AQUIND INTERCONNECTOR

Applicant's Response to Deadline 3 Submissions

This Document has been edited by Winchester City Council and now only contains the responses relevant to WCC. plus the Councils comments on those responses.

PINS REF.: EN020022 DOCUMENT: 7.9.17

Plate 1 - Plots 3-12 and 3-13 as shown on Land Plan as at Application

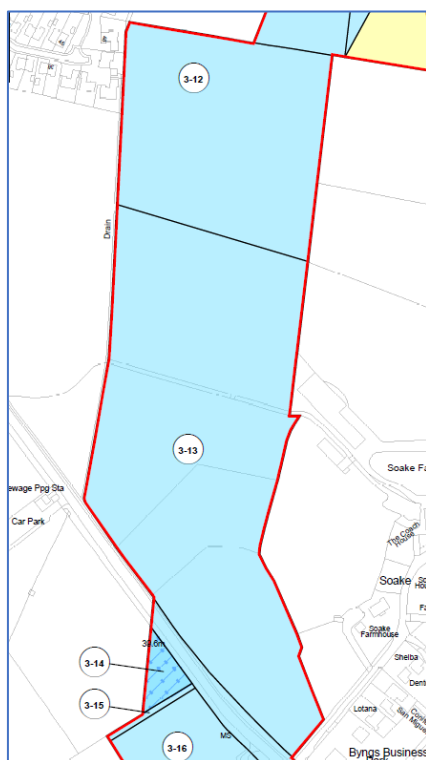
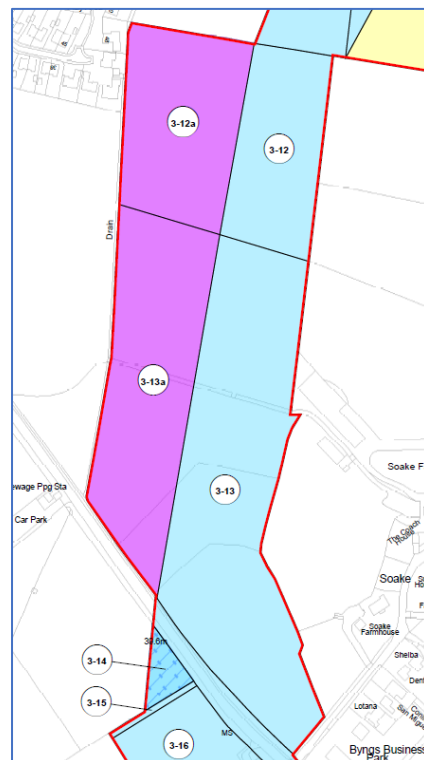
Para No.	Comment	Applicant's Response	Winchester Comment on Applicants D4 submission
7.7.4	Position Statement in Relation to the Refinement of the Order (REP1-133)	7.7.4	
	The Council has a concern relating to the adjustment to the Order Limit at Soake Farm as described in section 3.3.1.6. Plates 1 & 2 show the existing and proposed arrangement. Whilst the area where the cable is to be installed is reduced, section 3.1.1.9 indicates that New Access Rights are to be retained over the purple area and there is a reference to the provision of a haul route at the end of the paragraph. These are now shown as land parcels 3-12a & 3-13a on sheet 3 of the Lands Plan (REP1-011).	The Applicant can confirm that any access rights required over Plots 3-12a, 3-13a and 3-12 as shown on the updated Land Plans (REP1-011a) would not require a haul road as installation of the Onshore Cable Route in this area would be by horizontal directional drilling (HDD) rather than open trenching and the reference to a haul road in the Position Statement in relation to the refinement of the Order Limits (REP1-133) was in error. It is possible a short length of haul road may be required in Plot 3-13, though this would be in relation to the HDD compound which could be located in the southern part of Plot 3-13 (immediately north of Hambledon Road).	Noted and clarification welcome.

The nature and degree of access for monitoring (by foot or vehicle) needs clarifying but the Council would resist the establishment of any haul route from north to south. Such a provision is not compatible with the HDD approach to the installation of the cables in this location which includes two SINC's.	For monitoring purposes access will be carried out on foot. The statement in relation to the haul road is an error. No haul road will be installed in plots 3-12, 3-12a, 3-13a. It is possible a short length of haul road may be required in Plot 3-13, though this would be in relation to the HDD compound which could be located in the southern part of Plot 3- 13 (immediately north of Hambledon Road). Habitat within Plot 3-13 comprises Lowland Meadow which is ecologically important. Ecological mitigation to restore this habitat following completion of the construction phase is proposed within ES Chapter 16 Onshore Ecology (APP-131), and expanded upon in the ES Addendum (REP1-139). It is secured through the OLBS (REP1-034) through requirement 9 of the dDCO (REP3-003).	This needs to be embedded in the DCO or the supporting Documents. The Book of Reference contains 8 separate Actions (a-h) that could be undertaken in an Access Rights area. WCC will respond on the Denmead Meadows situation in a separate paper at D6

TITLE: **AQUIND Interconnector Order Limits version 8.0 Sheet 3**

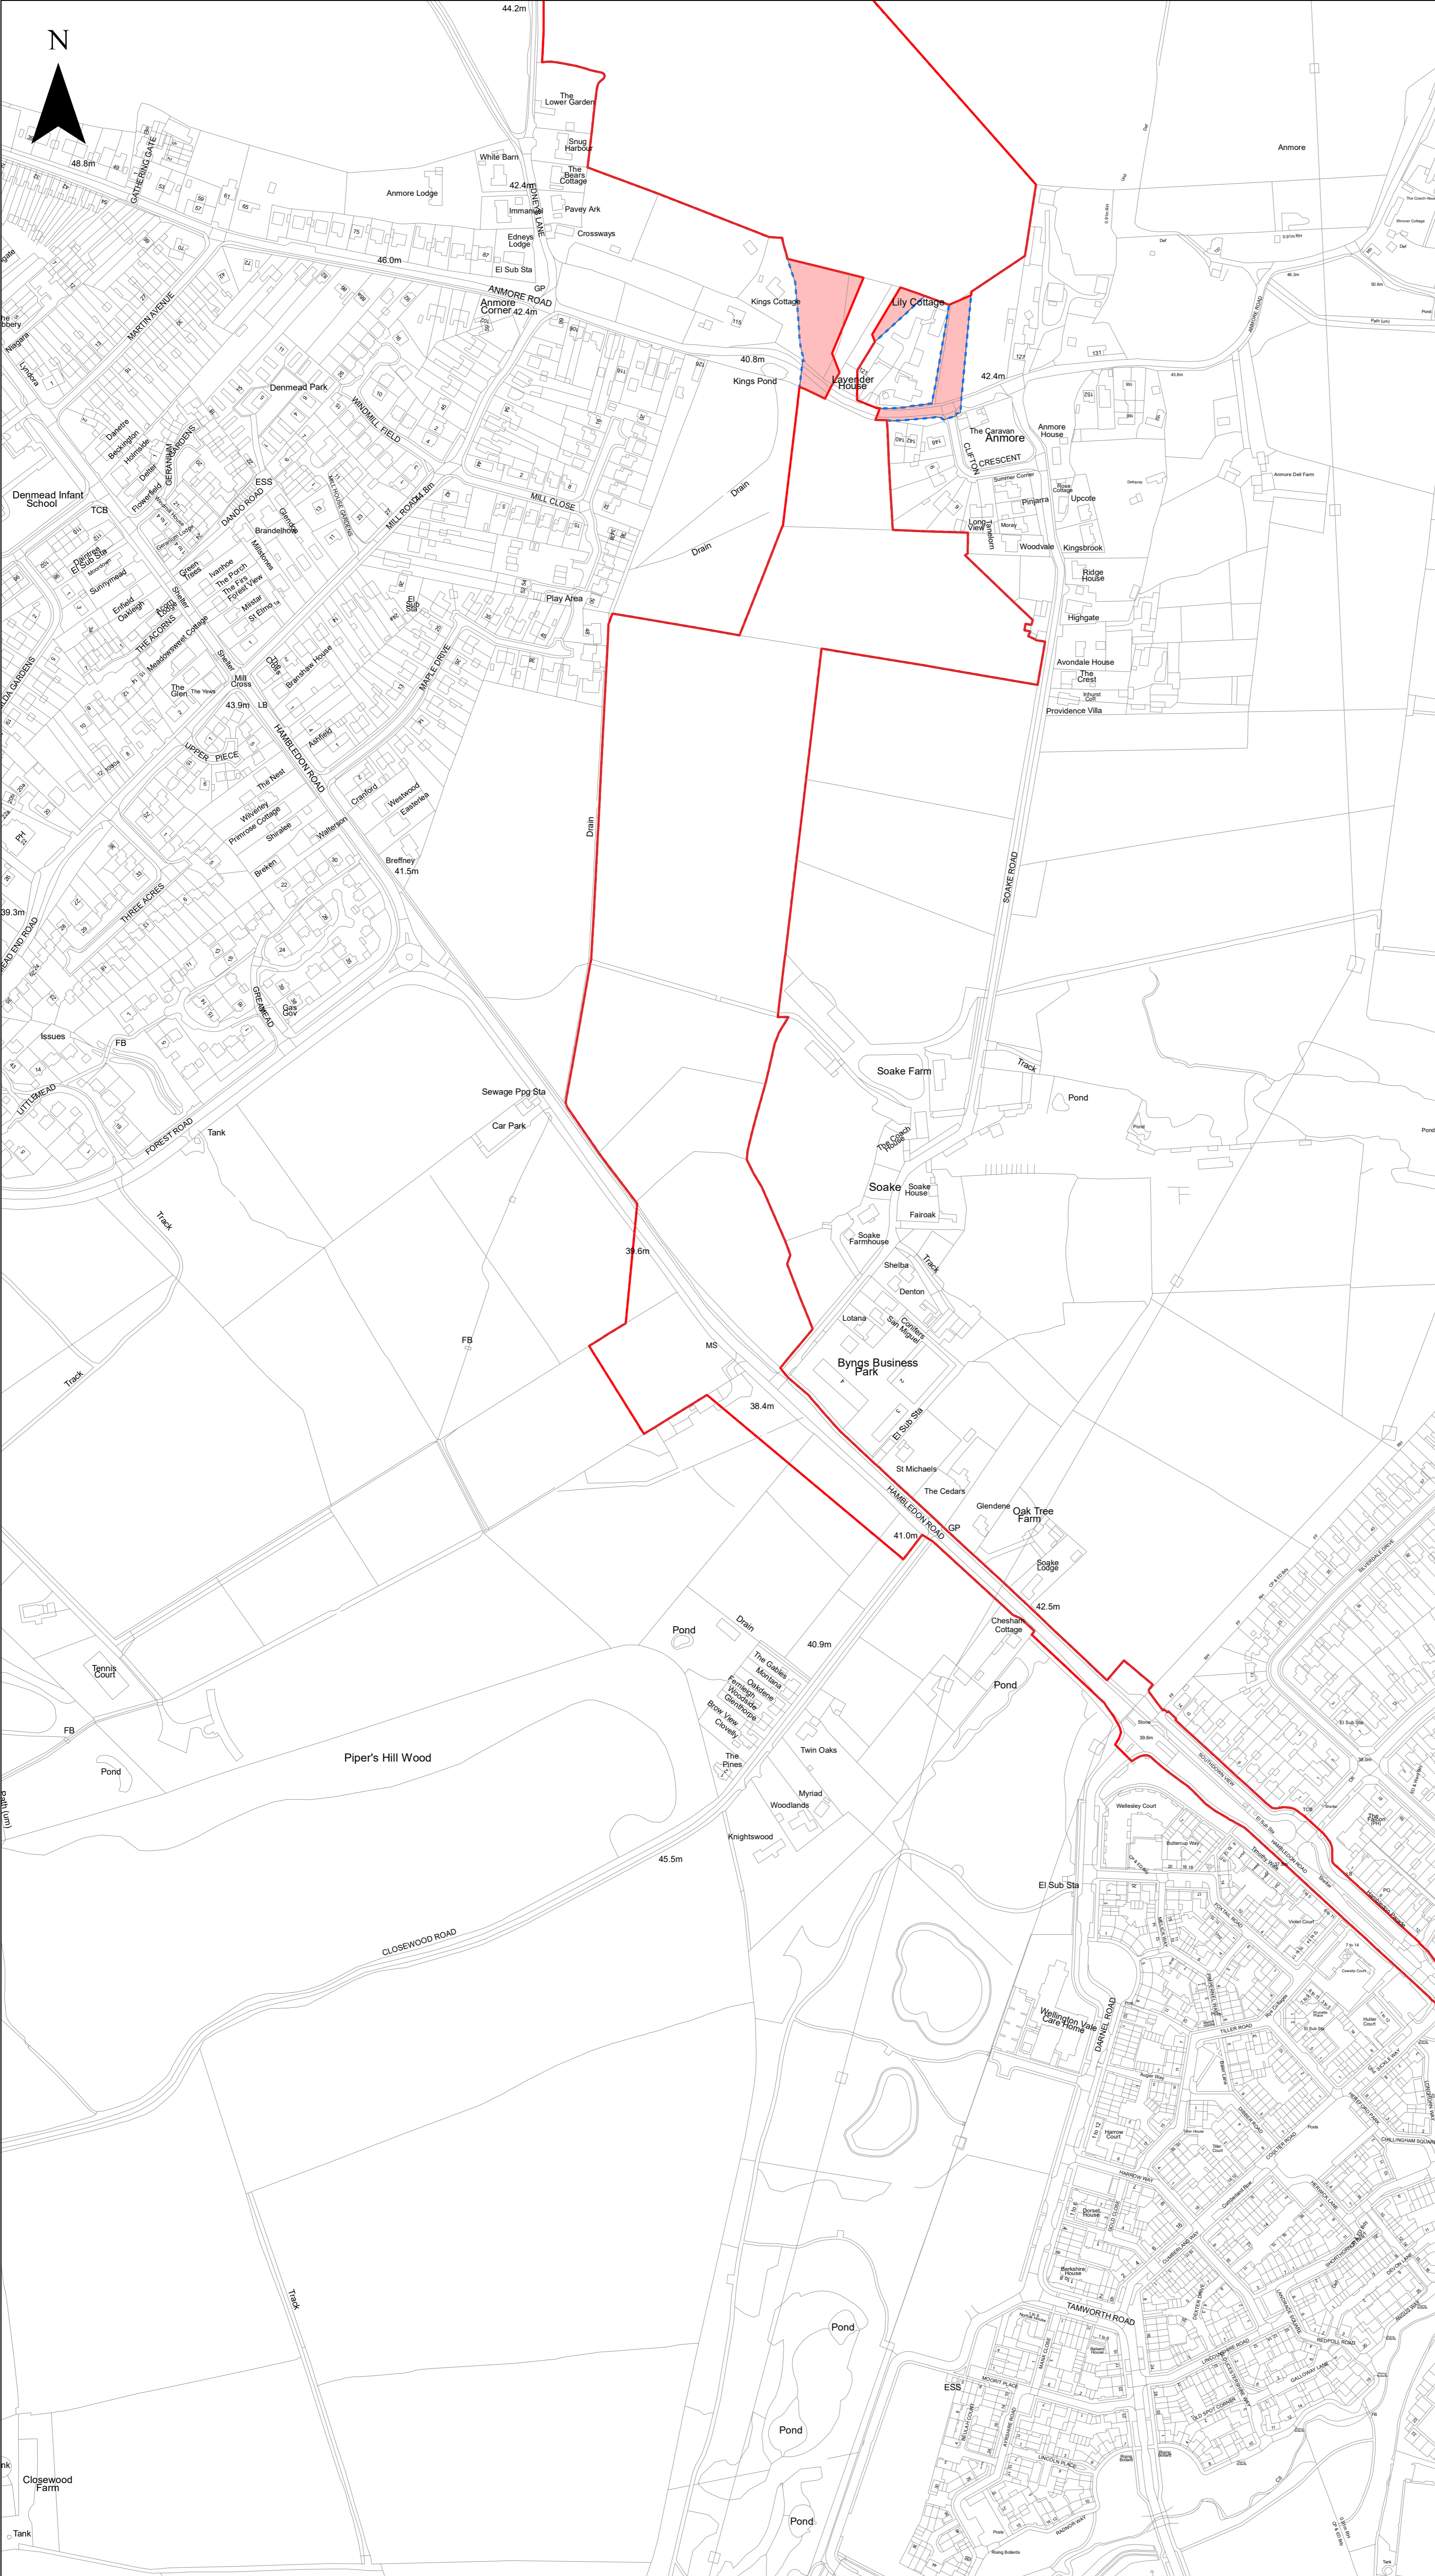
The Council questions if the applicant cannot release the land to the south of Hambledon Road from the proposal. These are land parcels 3-14, 3-15, 3-16 & 3-17 as shown on sheet 3 of the Lands Plan (REP1-011).It is understood that this was originally considered as a location to launch the HDD, but that launch site now appears to be located on land on the north side of the road. If this is the case, then the southern land is no longer needed. If it is to be retained, then a discussion is needed on the way that land will be used and its impact on the close knit features that surround and divide up that ground.	Plots 3-14, 3-15, 3-16 and 3-17 have been retained to provide flexibility for the location of Horizontal Directional Drilling The Applicant notes the need for a discussion regarding usage of land and possible impacts and will facilitate those discussions.	Is the applicant proposing that this flexibility is retained throughout the Examination with no final decision made until contractors are involved? It is hoped that at some stage in the examination process the applicant will make a final decision. This seems to be the application of the Rochdale Principles with alternative sites for the HDD5 launch compound arising here. This discussion can form part of the conversation on Denmead Meadows

Aquid Countryside Option

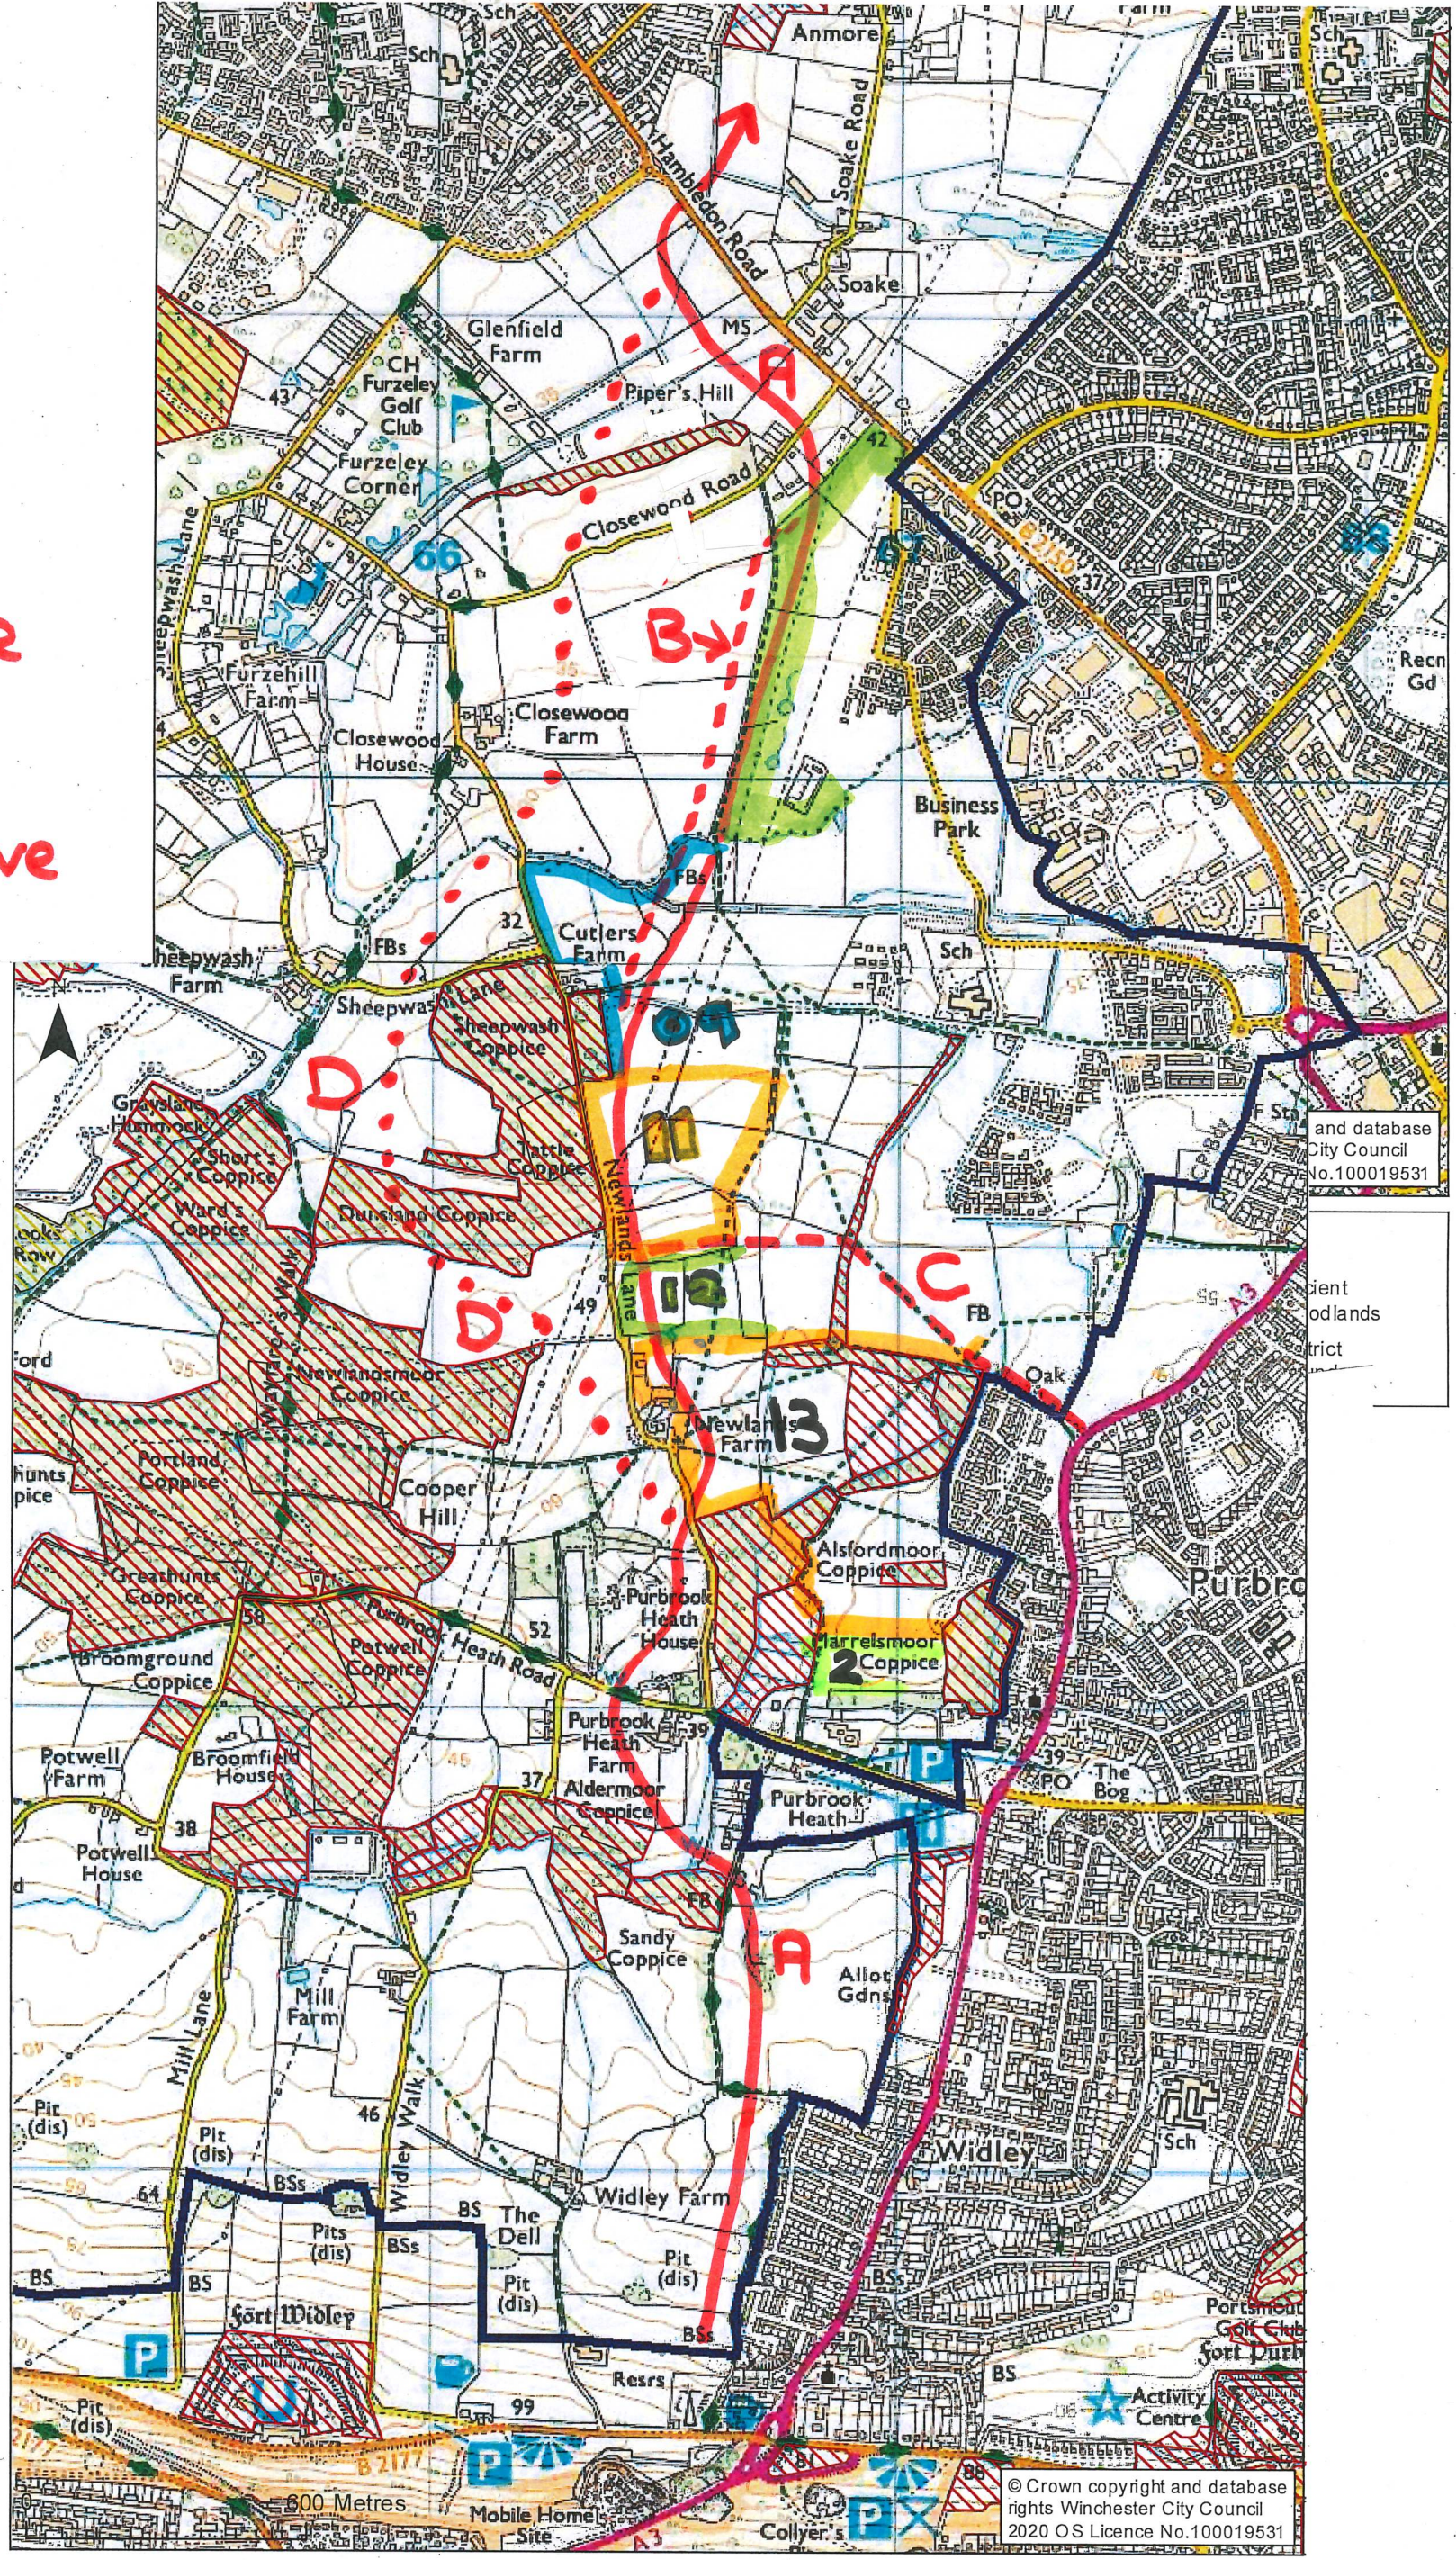
4.6.4.2	<p>The Supplementary Alternatives Chapter lacks a clear time line setting out exactly when the applicant considered the countryside route.</p>	<p>The applicant provided a more detailed response to this in Table 2.2 of REP3-014.</p> <p>In summary, the consideration of a cable route in this location was first considered in 2017, however it was discounted at this stage because of the potential for environmental impacts on designated sites and because the Applicant did not want to sterilise the land in this location, noting that it is an area allocated for housing development. Following the suggestion of the alternative countryside routes by HBC and WCC in responses provided at the AQUIND public consultation on 16th and 29th April 2019, respectively, the potential for a route in those location was further considered, with that further consideration confirming the previous conclusions made.</p>	<p>The ES Chapter 2 reference to the 2017 route consideration was an assessment of road routes only. (Plate 2.9 DC Cable Route Options). The Councils letter dated 1 September 2020 (PDB-006) sets out the chronology of the options considered as detailed in the application. If the applicant has other background records of assessments that did not feature on chapter 2 the Council would welcome sight of them.</p> <p>To date, despite several invitations, the applicant has still not provided a clear chronology of any further "background assessments" of when the cross country route was considered in the context of the other routes and the level of detail that any assessment considered.</p>

<p>4.6.4.8</p>	<p>The applicant makes general statements that the countryside route was considered but fails to identify the specific time in the optioneering process when this occurred.</p>	<p>See response to paragraph 4.6.4.2 in this table.</p>
<p>4.6.5.1</p>	<p>Noted and accepted. Noted and welcomed providing the TPO tree and its root system are not impacted in any way. The dDCO should be amended to reflect this.</p>	<p>It is assumed the reference to the TPO tree is to T393. As confirmed within the OLBS (REP1-034): "<i>The Onshore Cable Route shall avoid impacting on the TPO'd oak tree (T393) (TPO - 2246 T1) to north of Anmore Road and a mature Category A oak tree (T409).</i>" This is also shown in Sheet 3, Figure 3 Tree & Hedgerow Retention Plans (REP3-007). Further, T393 has been removed from Schedule 11 to the dDCO (REP3-003).</p>
